SPR EA1N and EA2 PROJECTS

DEADLINE 9 – COMMENTS ON NATIONAL GRID SUBSTATION EXTENSION APPRAISAL

Interested Party: SASES **PINS Refs:** 20024106 & 20024110

Date: 15 April 2021 **Issue:** 1

Figure: 8g
CHVP3: PROW between Moor Farm and Little Moor Farm

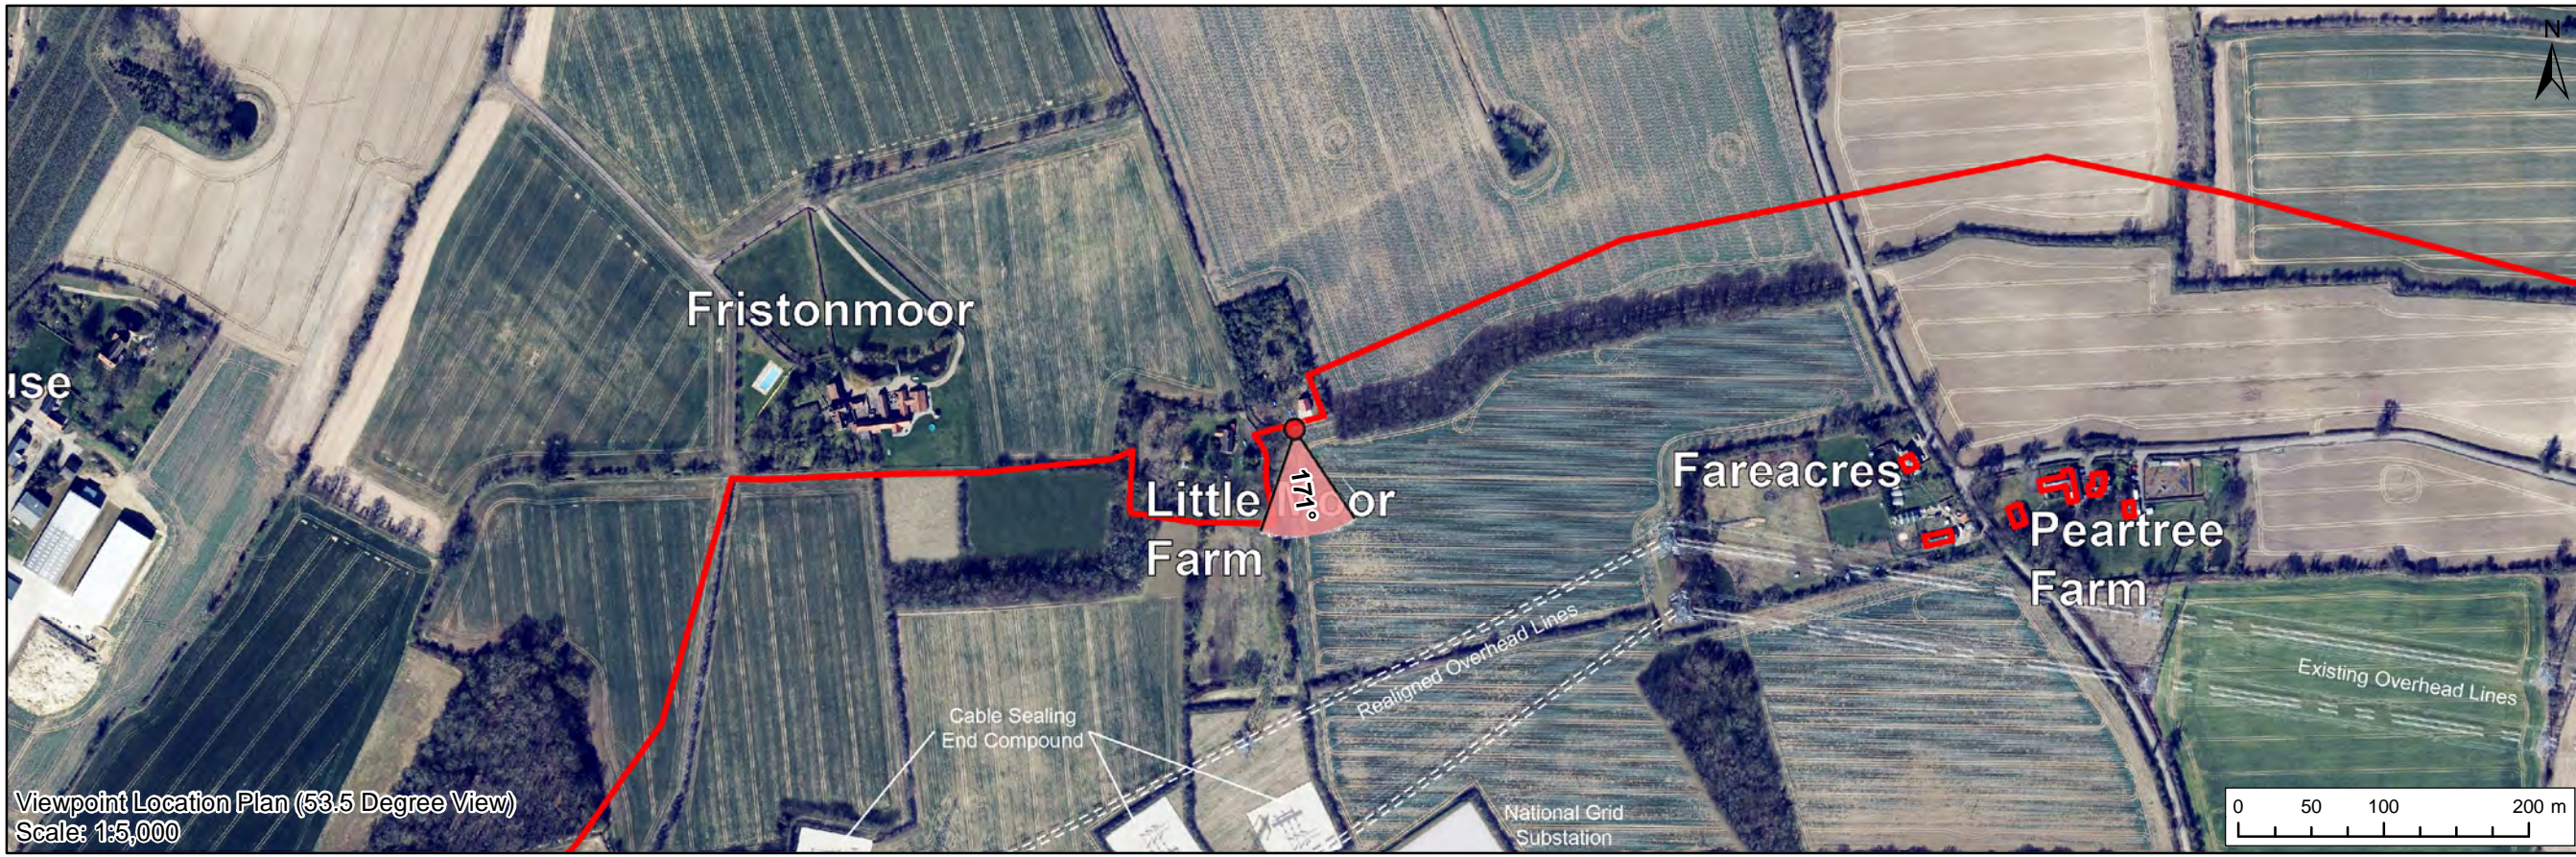
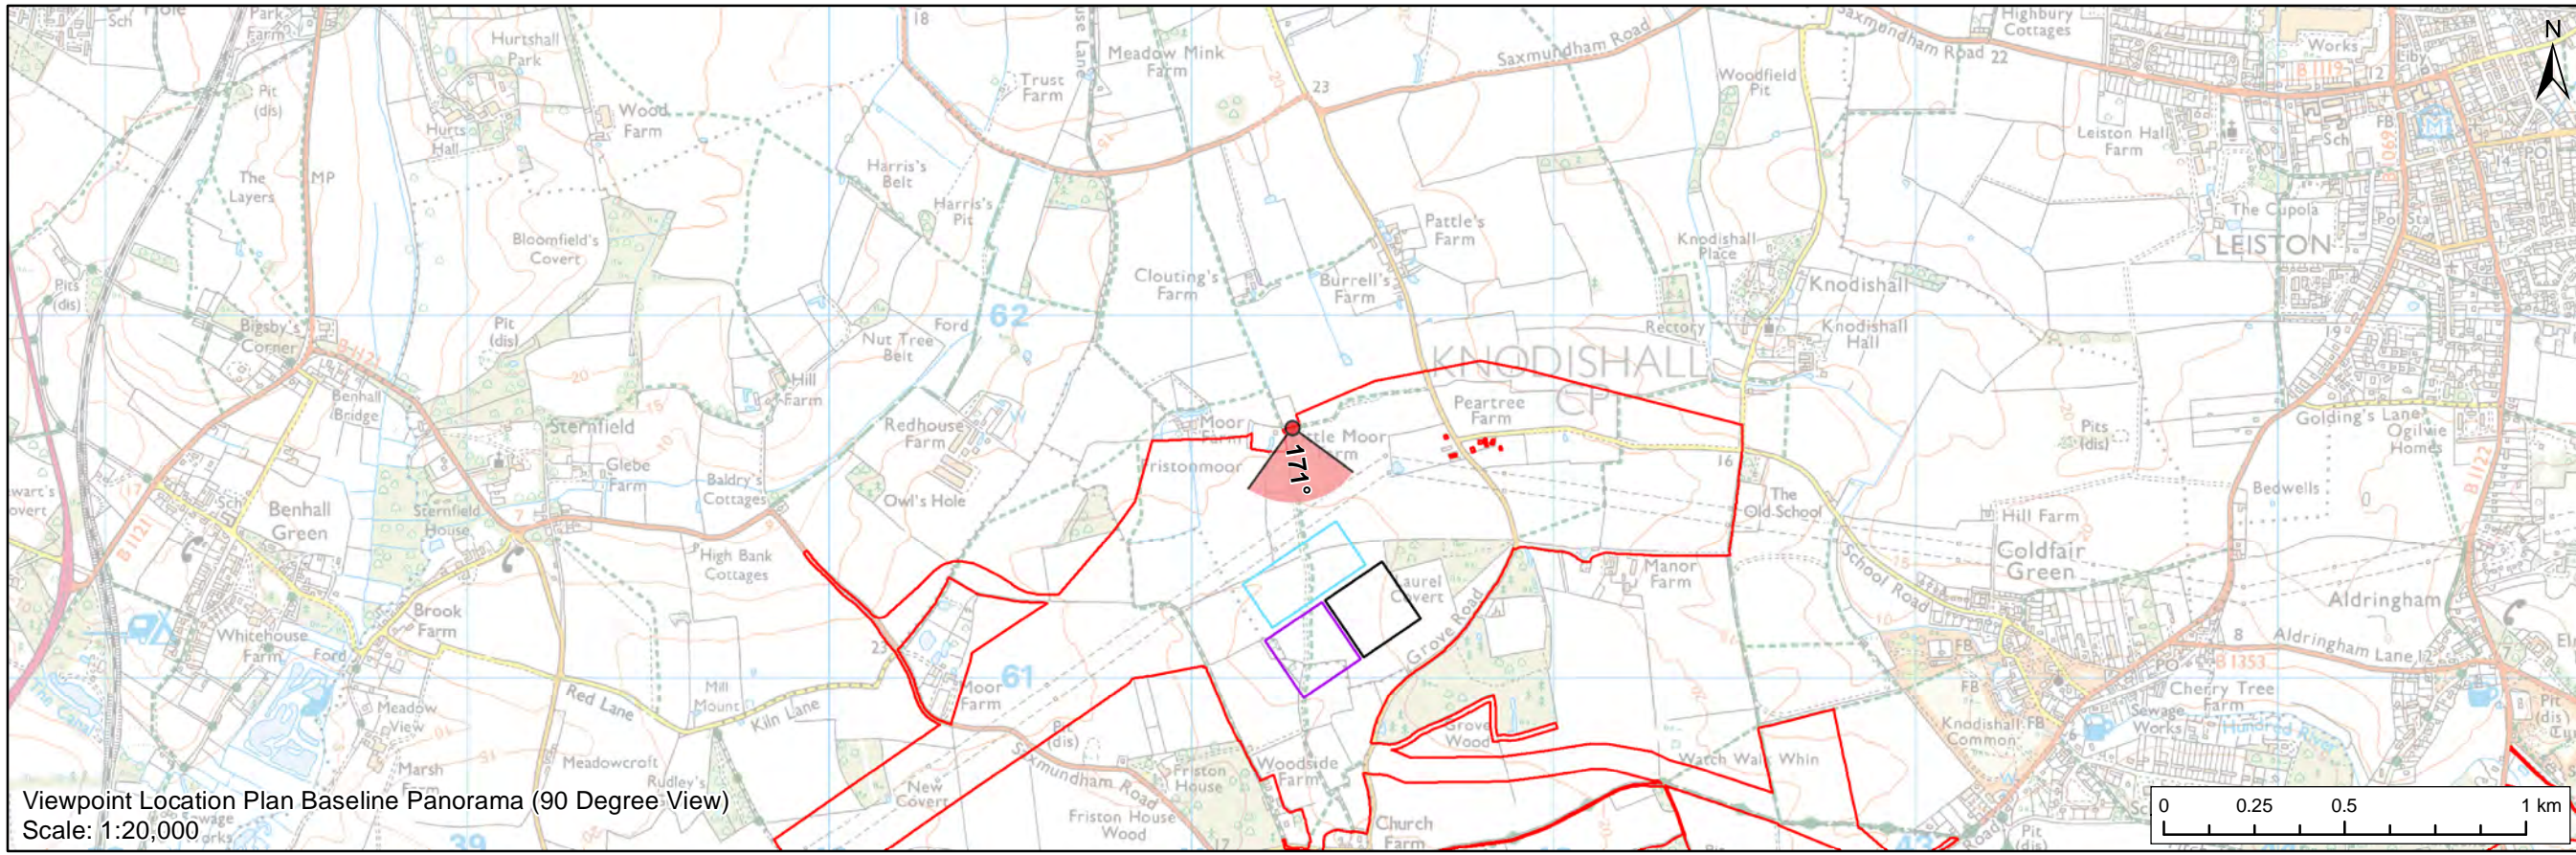
10. Further photomontages have been submitted showing the GIS option for the NG substation, both LVIA and CH viewpoints. CHVP3 and CHVP4 are taken from PRoWs close to the location of LVIA Vp 5. A revised photomontage showing the GIS option LVIA Vp 5 was submitted at Deadline 6 and commented on in MBELC Briefing Note 7.

11. Taken together, the photomontages from LVIA Vp 5, CHVP3 and CHVP4 show the extent of the harm to the landscape in this area. In particular they show the harm to the visual amenity of the network of footpaths which will be severed visually from the village of Friston; current views of the church tower as seen on the edge of the village will be further obscured.

Figure: 29.21b  
Viewpoint 9: B1121 Aldeburgh Road, south of Friston

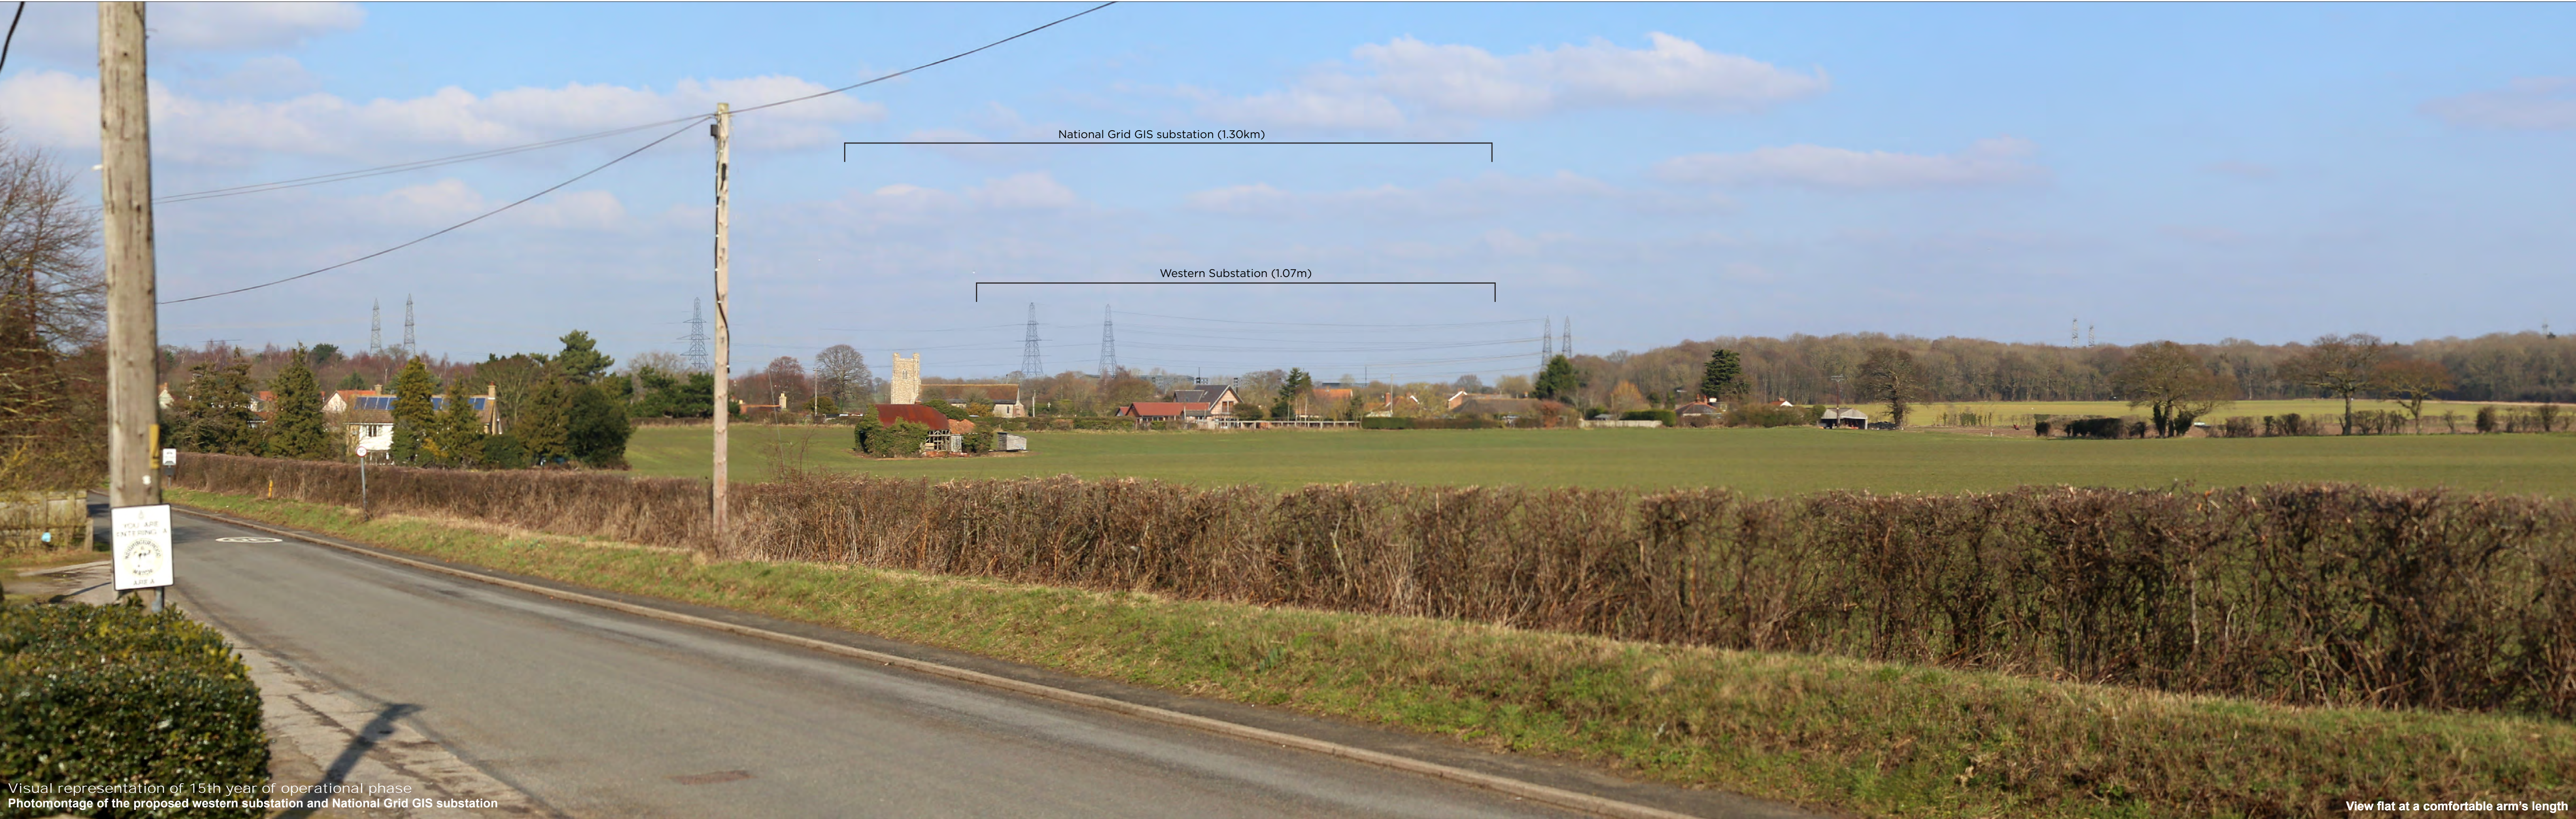
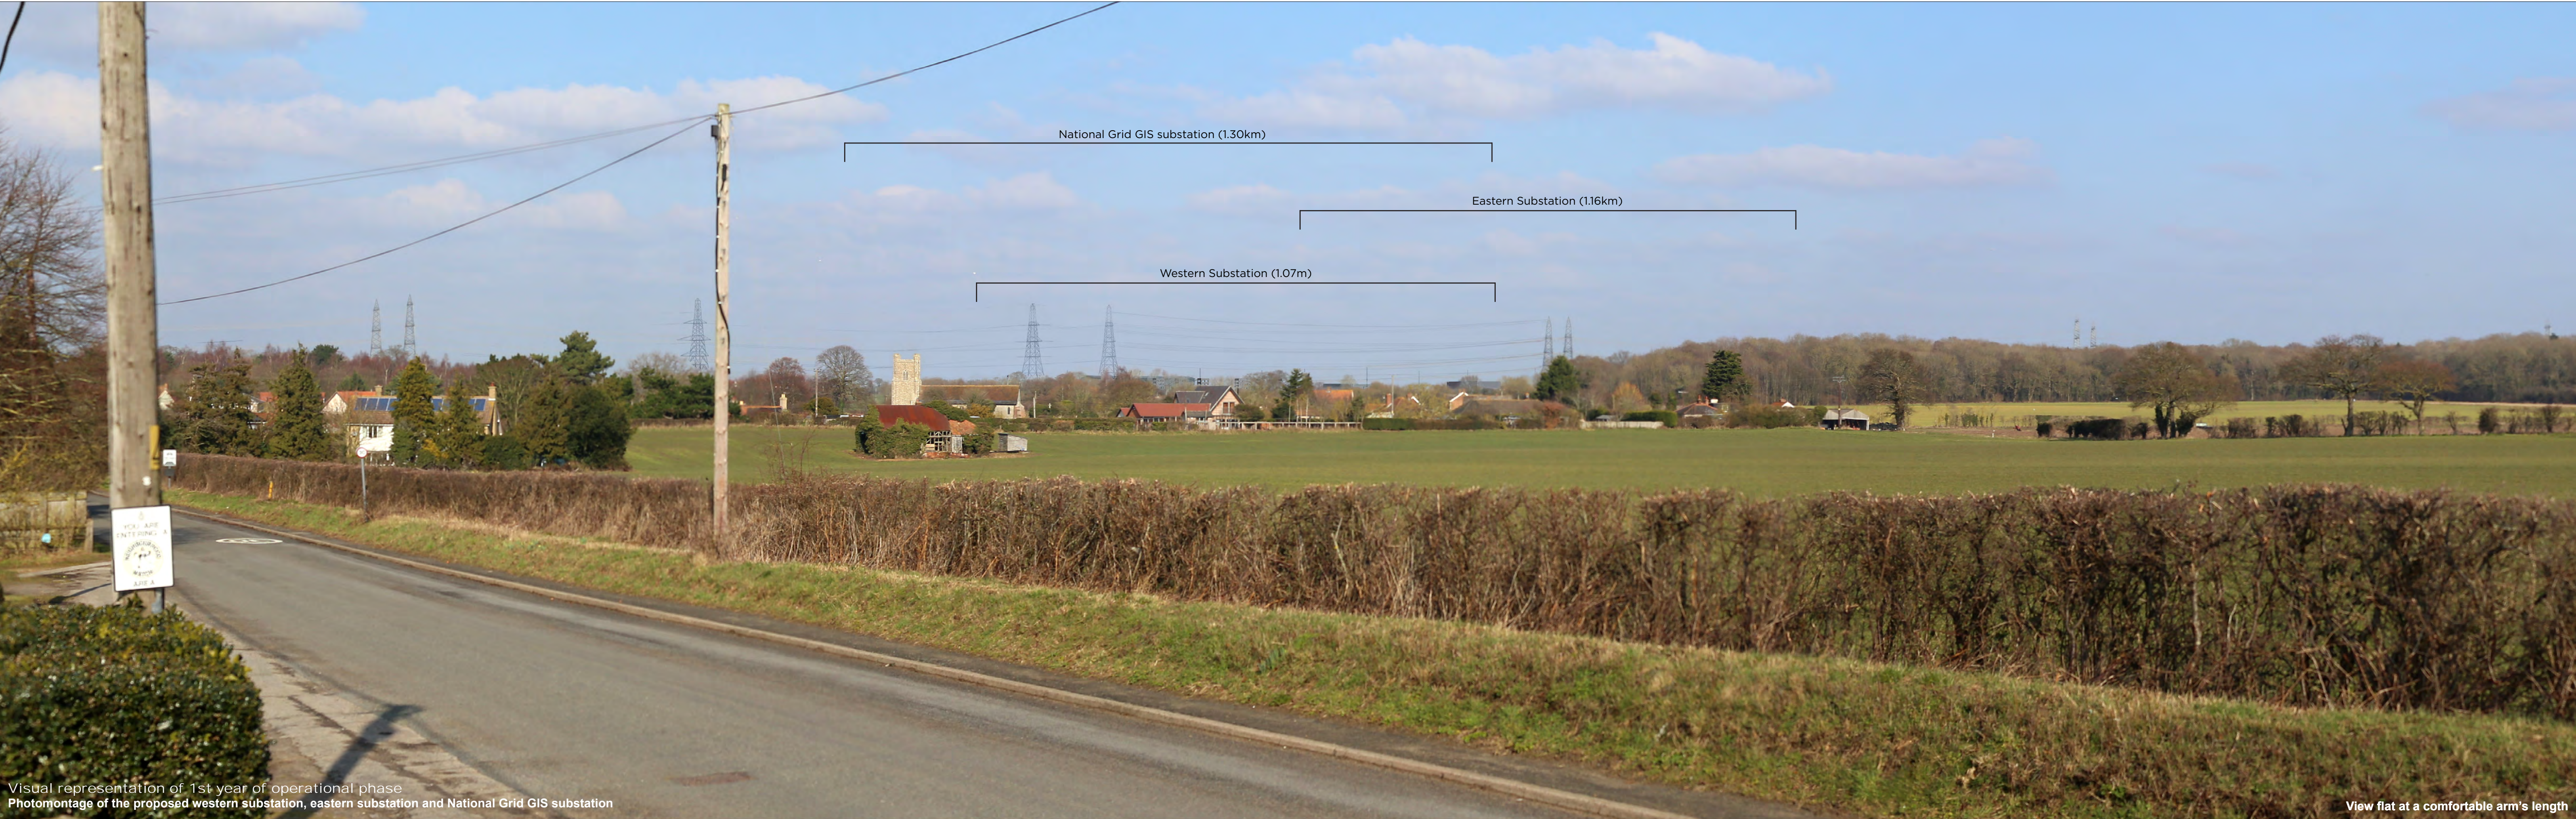
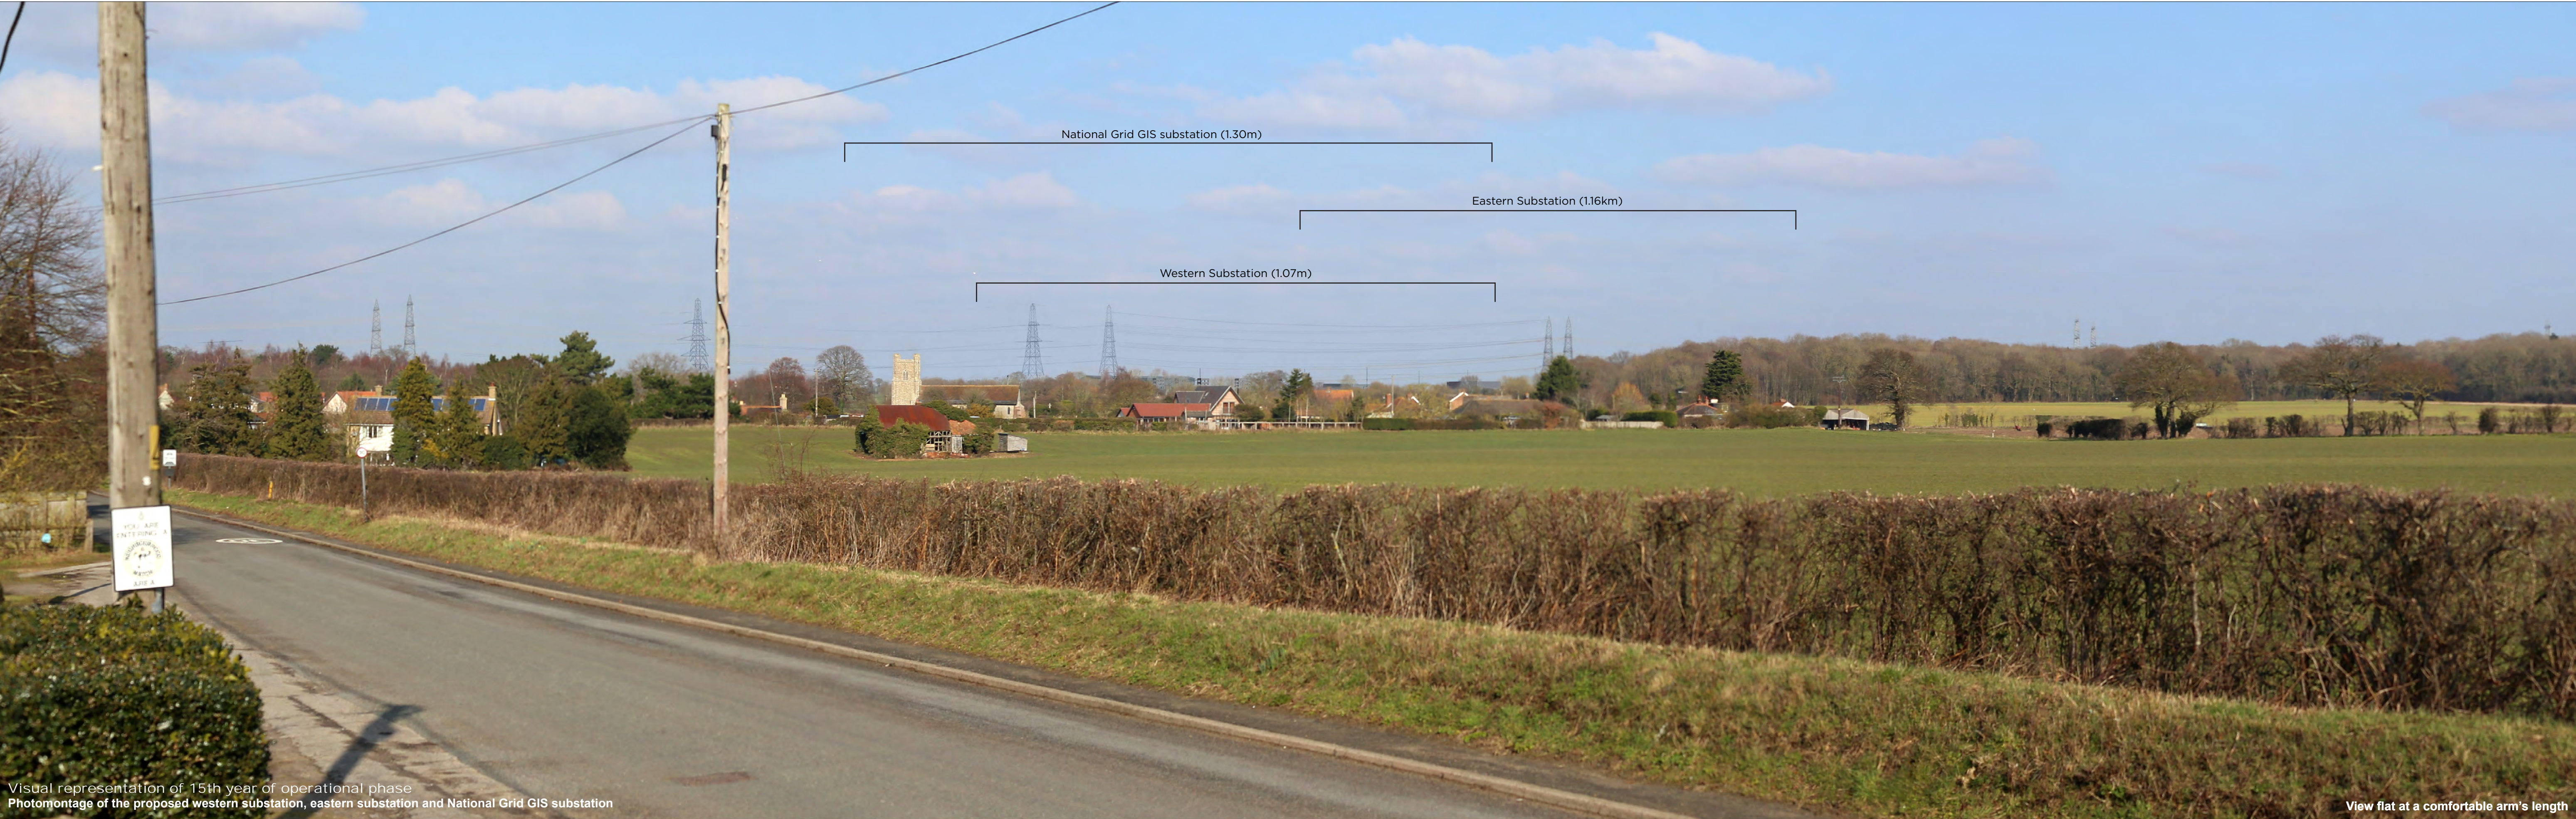
12. Comparing the photomontages that have been prepared for the GIS versus AIS NG substation it is clear that what may be an advantage from one viewpoint is a disadvantage from another. For example, in MBELC Landscape Briefing Note 8 we noted that for LVIA Vp 5 the landscape and visual effects of the AIS substation were greater than the GIS substation. However, from CHVP 4 the bulk of the buildings within the GIS station are particularly intrusive and difficult to mitigate. Similarly, whilst the western NG extension would be most harmful from LVIA VP 5 it is the eastern NG extension that would exacerbate the visual spread of the development from CHVP 4.
